FRISTON PARISH COUNCIL

NATIONAL GRID ELECTRICITY TRANSMISSION - SEA LINK PROJECT

Date: 23 April 2026

DEADLINE 6 – OFH3 SUBMISSION

**Viewpoint 1: Public Footpath (Saxmundham 460, route 23), east of Saxmundham, looking southeast**

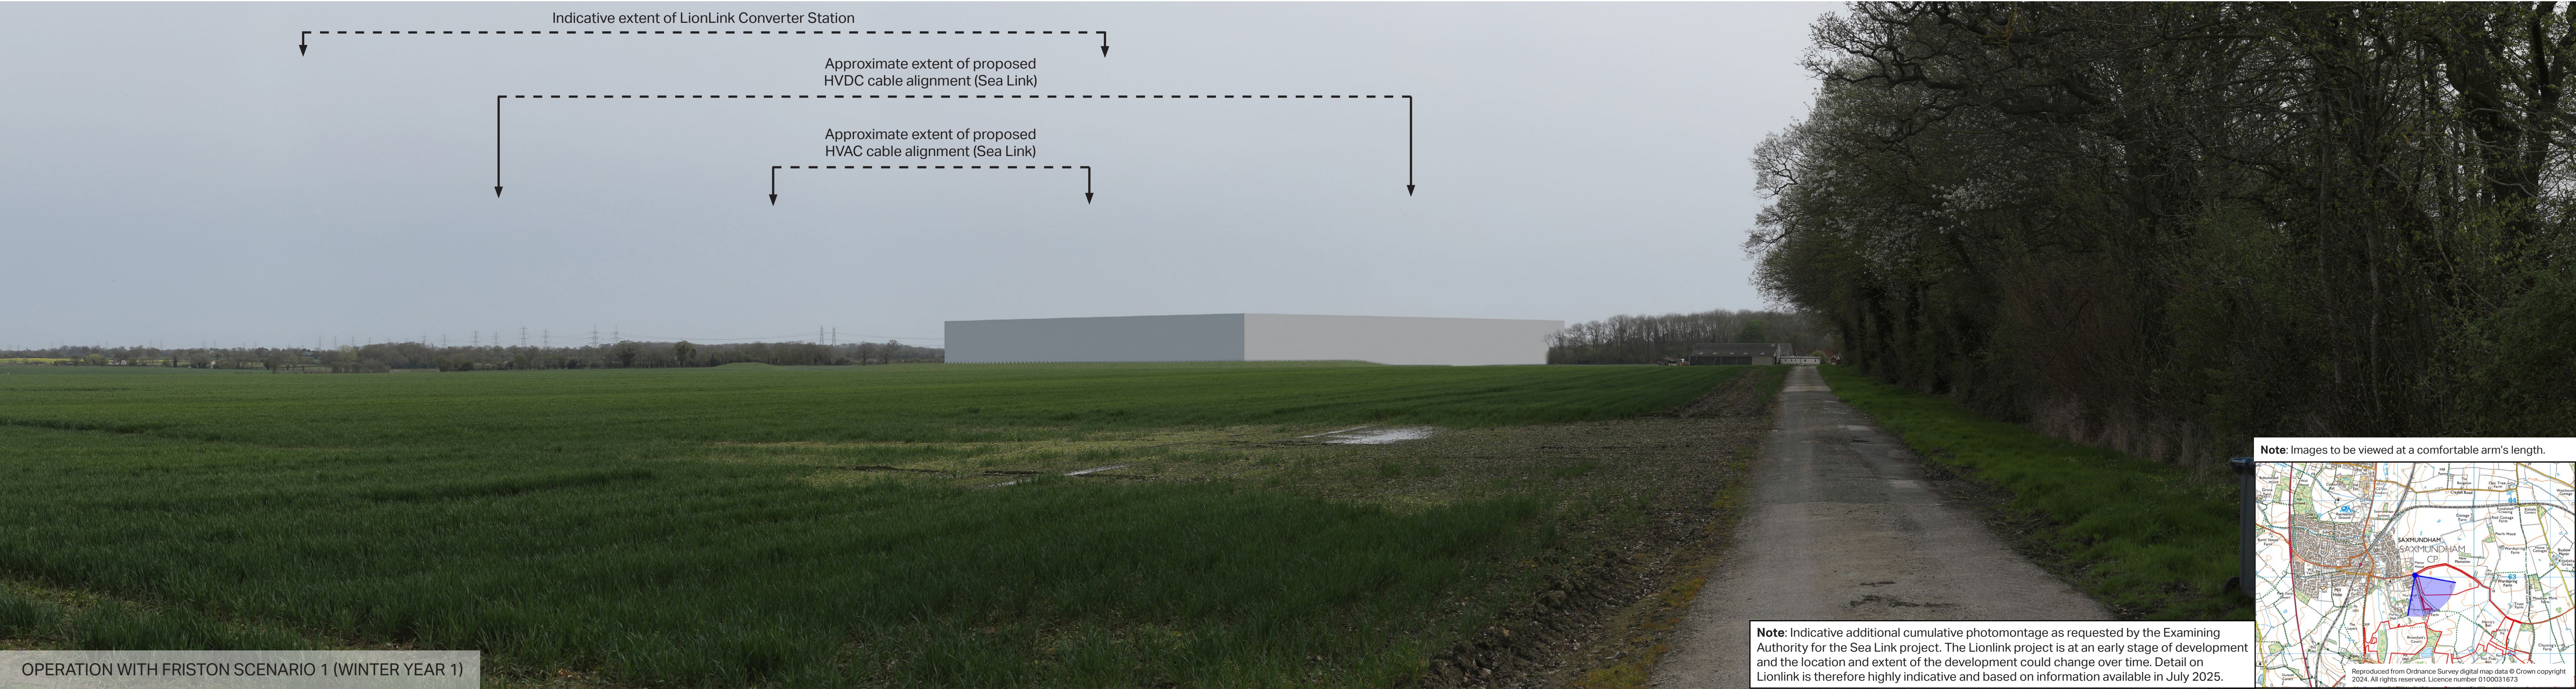
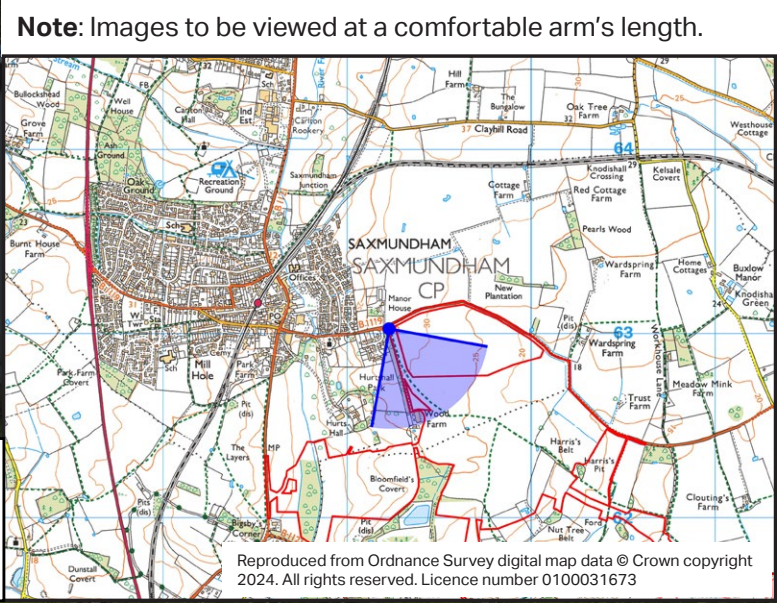
Fourth the requirement to protect against uncontrolled permitted development, requirement 44 in the Scottish Power DCOs, should be reinstated. In that context it was telling that National Grid produced no visualisation of the expansion of the National Grid substation for the Lionlink project. No doubt because they felt that they were free to expand the National Grid substation without reference to any planning authority.
